CITY OF ALBUQUERQUE

Re: ANM Jefferson Plaza
4001 Jefferson Plaza NE Albuquerque NM 87109
Traffic Circulation Layout
Engineer's/Architect's Stamp 01-08-19 (F17-D016E2)

Based upon the information provided in your submittal received 01-14-19, the above referenced plan cannot be approved for Building Permit until the following comments are addressed:

## EXISTING ADA PARKING SIGNAGE

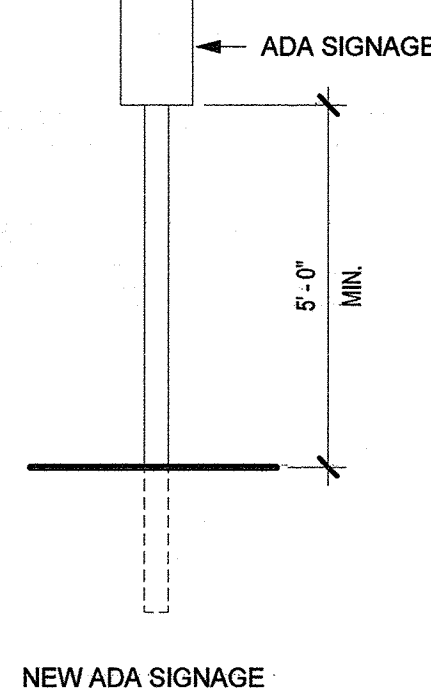
4. The ADA accessible parking sign must have the required language per 66-7-352.4C NMSA 1978 **"Violators Are Subject to a Fine and/or Towing."** Please call out detail and location of HC signs.

## TRAFFIC CIRCULATION LAYOUT

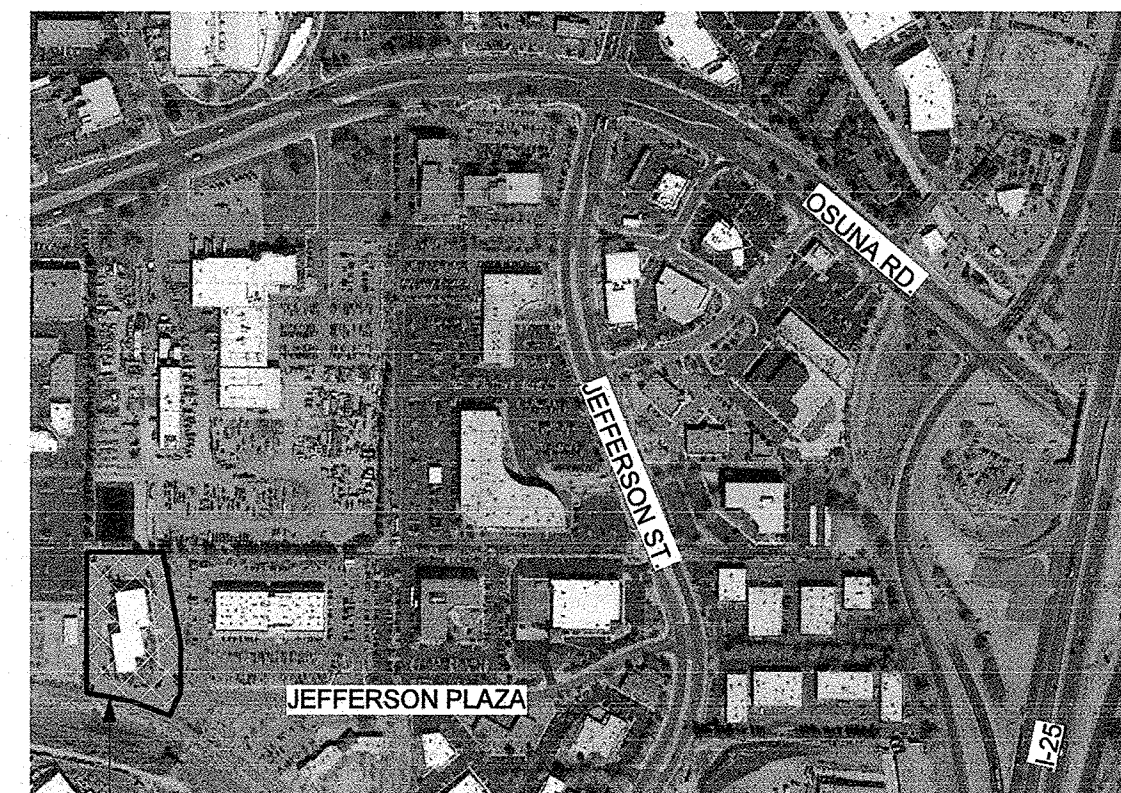
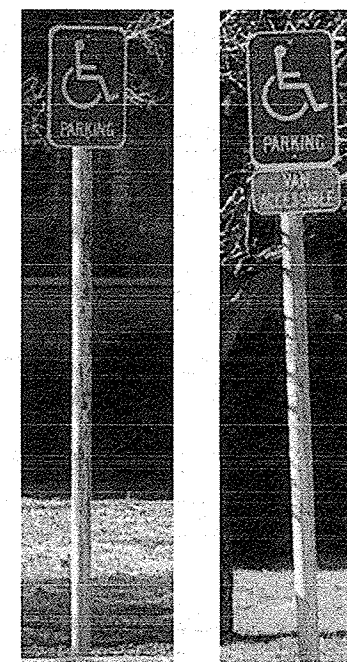
2. Please list the width and length for all existing and proposed parking spaces. Some dimensions are not shown.
3. The handicap accessible spaces must include an access aisle. Van accessible aisles should be 8ft wide; all others should be 5ft wide.

5. ADA curb ramps must be updated to current standards and have truncated domes installed.
6. On-Street parking credit to fulfill zoning's parking requirement must be requested and approved by the Traffic Engineer, Racquel Michel prior to TCL approval. The application requires at least 45 working days. On-street parking credit is based on available parking along public right-of-ways fronting the property. The business will only be granted 50% credit for available street parking.
